RESPONSE TO PLANNING APPLICATION 19/02948/F
Erection of ten residential dwellings off South Side, Steeple Aston

Thank you for consulting Mid-Cherwell Neighbourhood Plan Forum (MCNPF) on this application. **Please see our comments in the right-hand column below**, which state our current view in relation to points raised in our objection to the previous application (shown in the left-hand column).

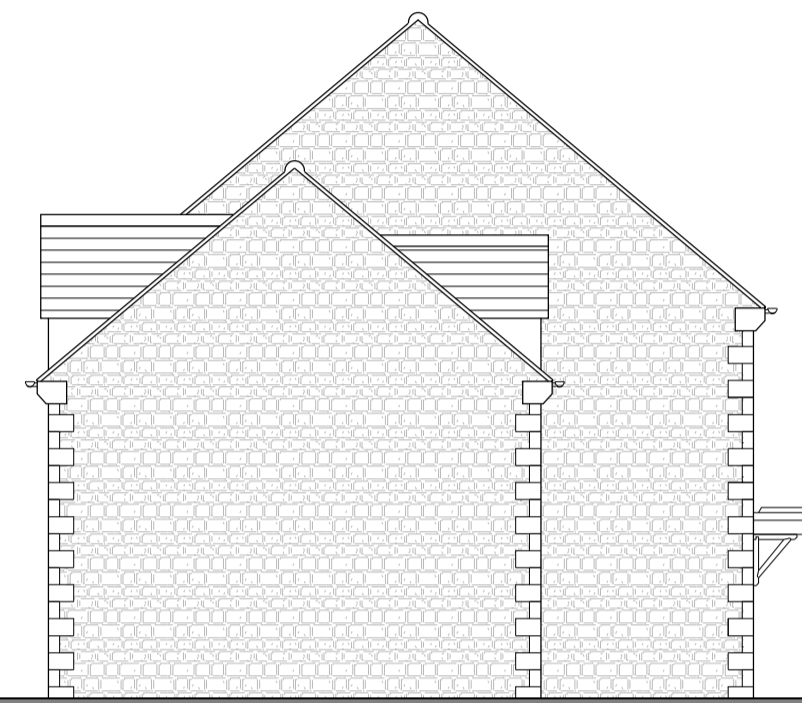
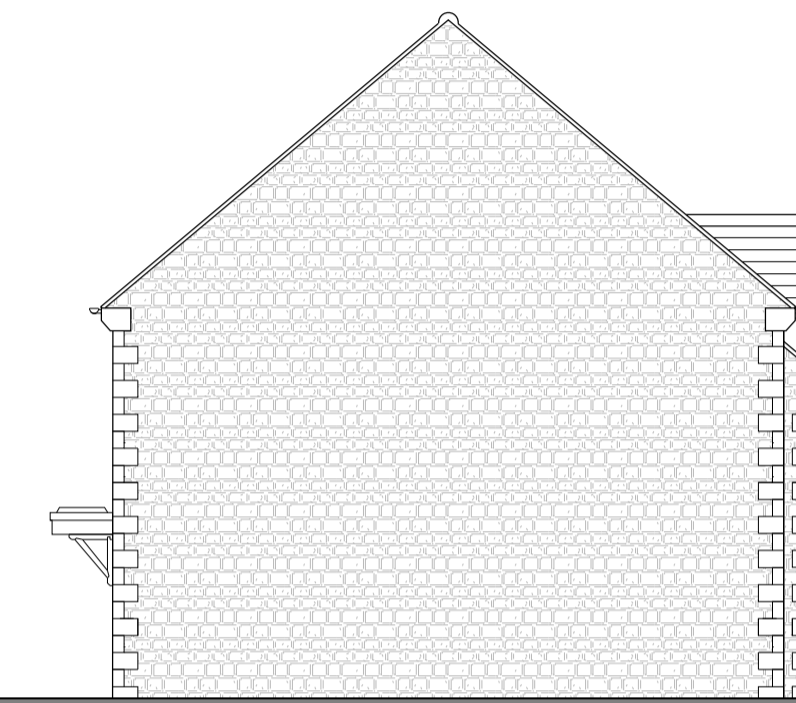
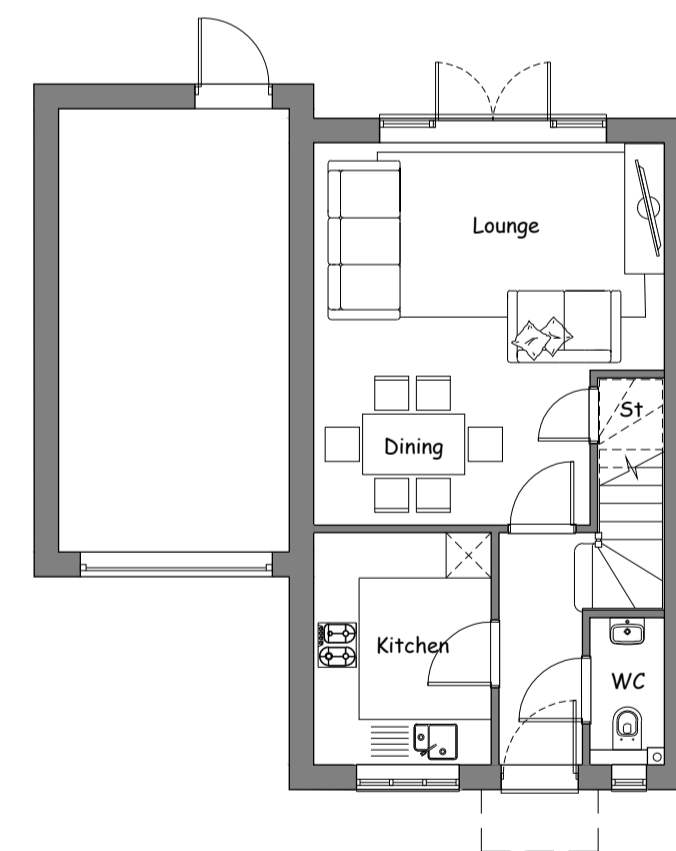
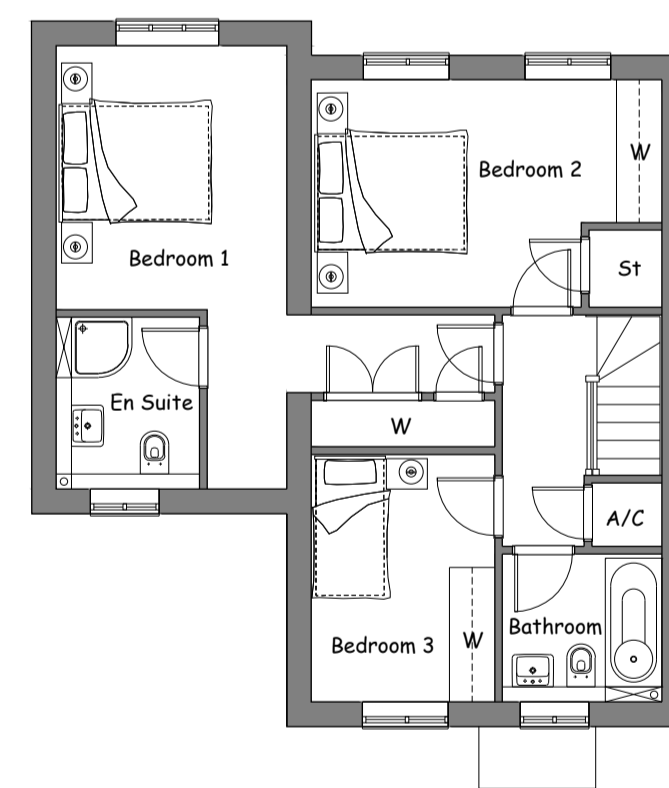
The remaining half-pair (plot 10) still jars as an alien form, and will mar the otherwise much-improved street scene. This pair of dwellings also noticeably lacks the chimney that has been added to the other houses: it would be better if it too were to be enhanced in this way.

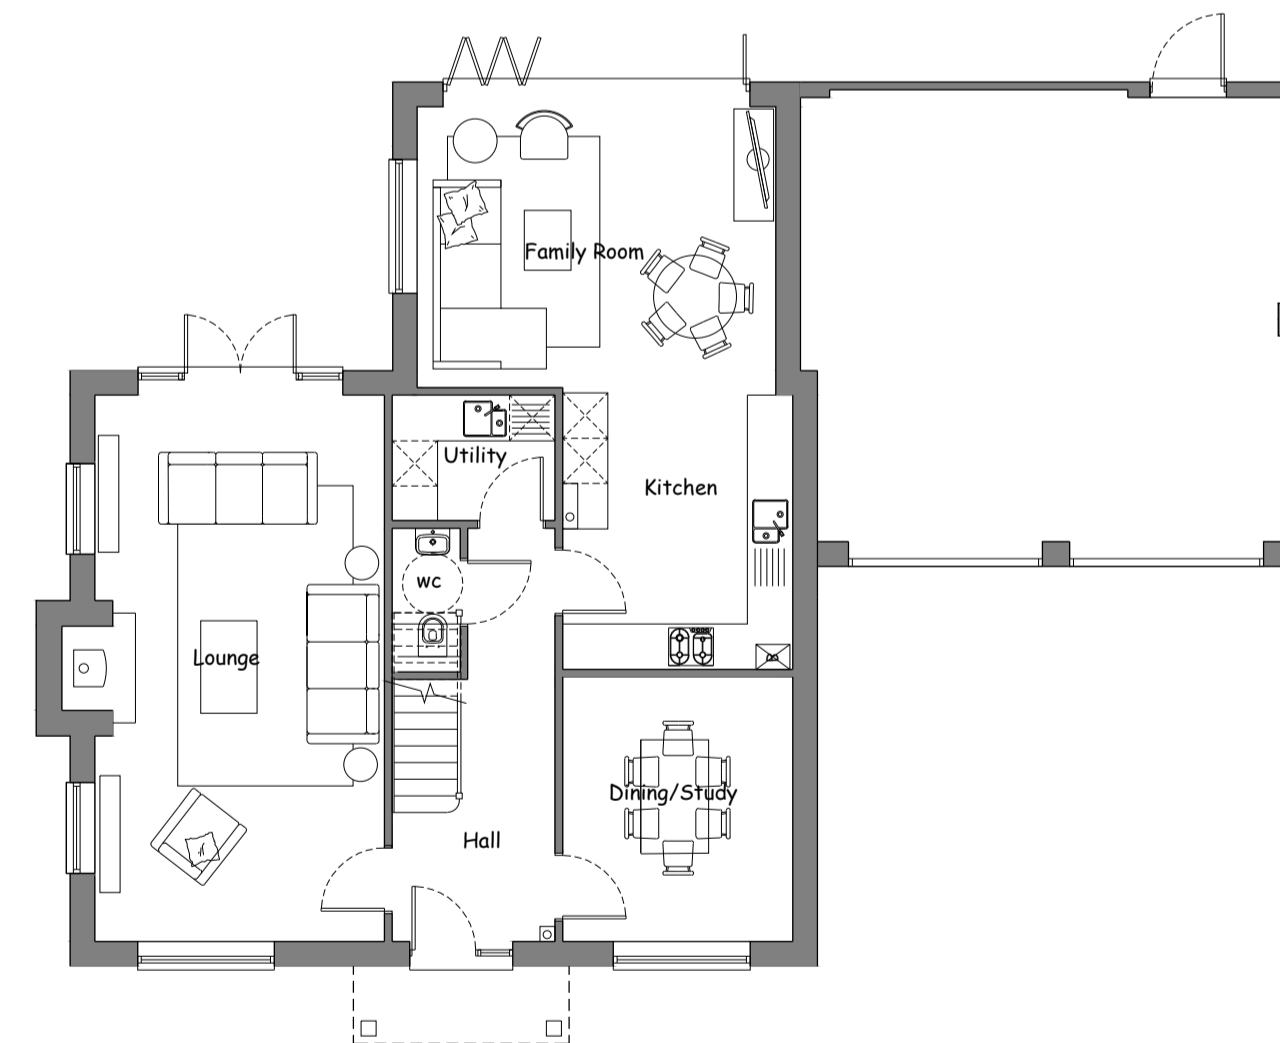
<p>with mobility. We would like CDC to apply a condition, relating to this MCNP policy, to any approval.</p>	
<p>Additional points: The close proximity of the 3-bed dwelling on plot 1 to the industrial use adjacent, being a car maintenance workshop, with planning approval for a large extension.</p> <p>the absence of any communal green space or play area for small children on the site; the popular play and recreational facilities adjacent to the Village Hall in Fir Lane are a considerable distance from the application site, and probably too far for parents and young children to walk. CDC policy BSC11 requires that developments of 10 dwellings or more must provide a Local Area for Play to the defined standards.</p> <p>a modest contribution to climate change concerns would be the inclusion of electric car charging points, well-designed photovoltaic panels on the south-facing roof slopes of each dwelling (which should be largely unseen from the road), and low carbon heating systems. MCNP Forum would like to see Rectory Homes providing an exemplar scheme in this regard.</p>	<p>The applicants have now addressed this potential issue with a noise barrier.</p> <p>MCNP Forum accepts that it is a reasonable alternative for a S.106 agreement to make a financial contribution towards improving the existing play facilities in the village. It is understood that the Parish Council is actively considering what contributions to village amenities would be appropriate.</p> <p>Car charging cables are now to be included. There is no mention of other climate change-related measures.</p>
